Your Ref: OWPC22218
Our Ref: BR/302/18/PL 21-11-2018
Please ask for:
Stuart Corbey

1 x 2 bedroom flat and 2 x 1 bedroom flat to the east elevation
71 Hawthorne Road Bognor Regis

Thank you for your internet representation made on 16th April 2019 which has been recorded as '**an objection**' with the comments as follows:

SITE PLAN (Proposed) @1:200

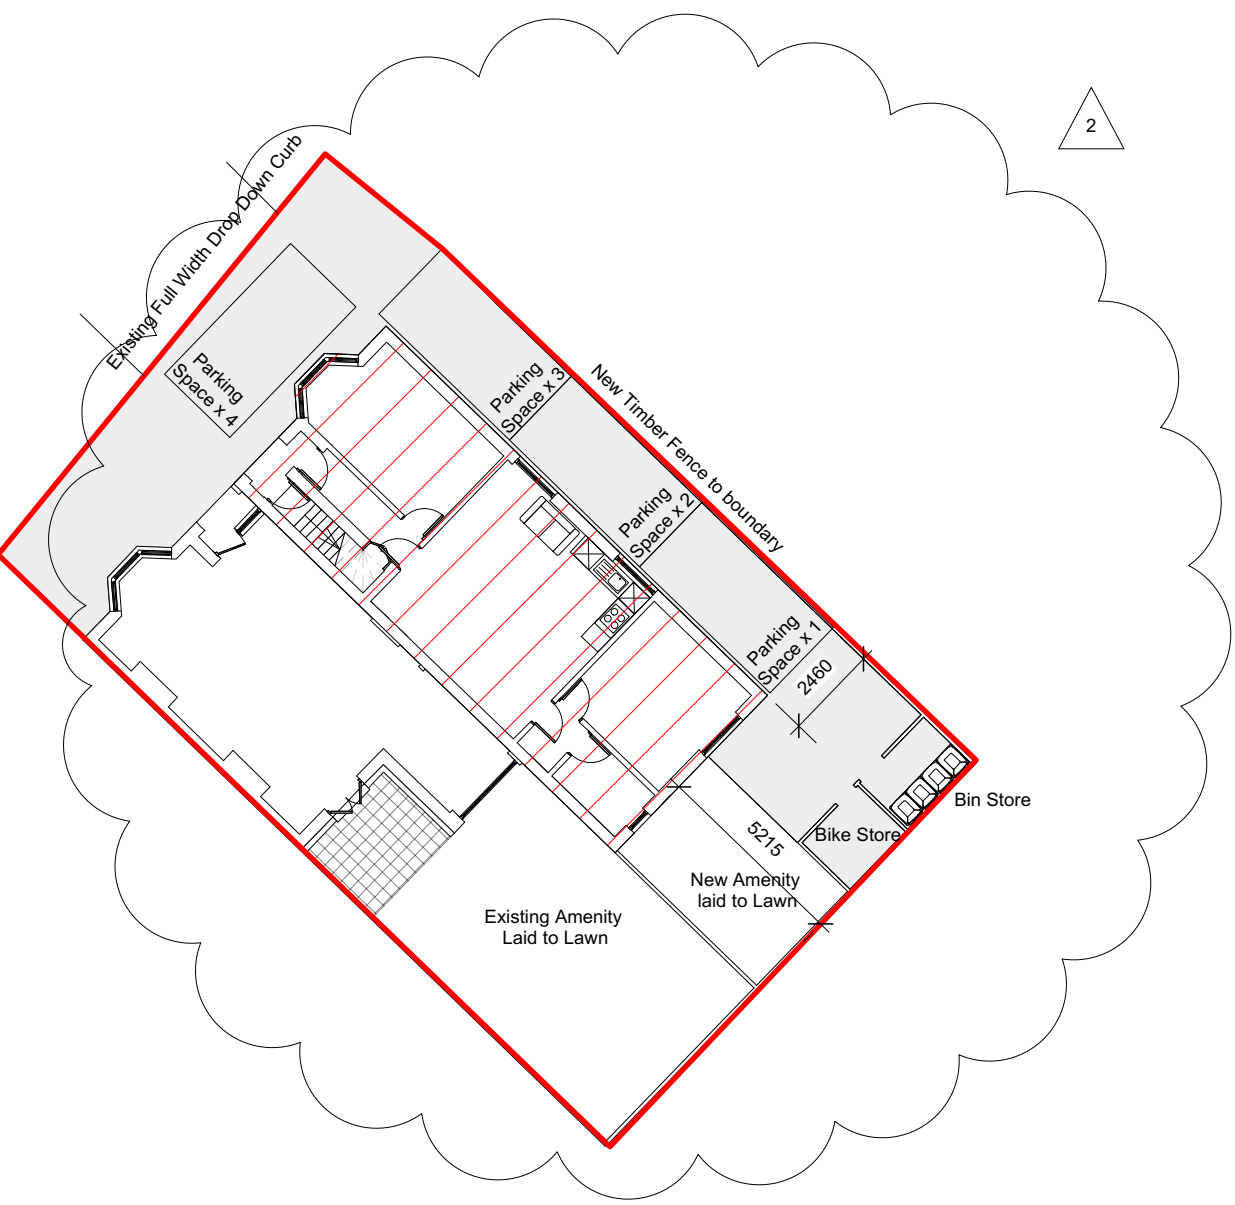
This is still overdevelopment of the site. The parking provision shown - three vehicles parked one behind the other - is impractical. Drivers from separate households will not be able to park in this way as it will mean continually having to ask someone to move their vehicle. In practice they will park on the road which is already full at evenings and weekends.
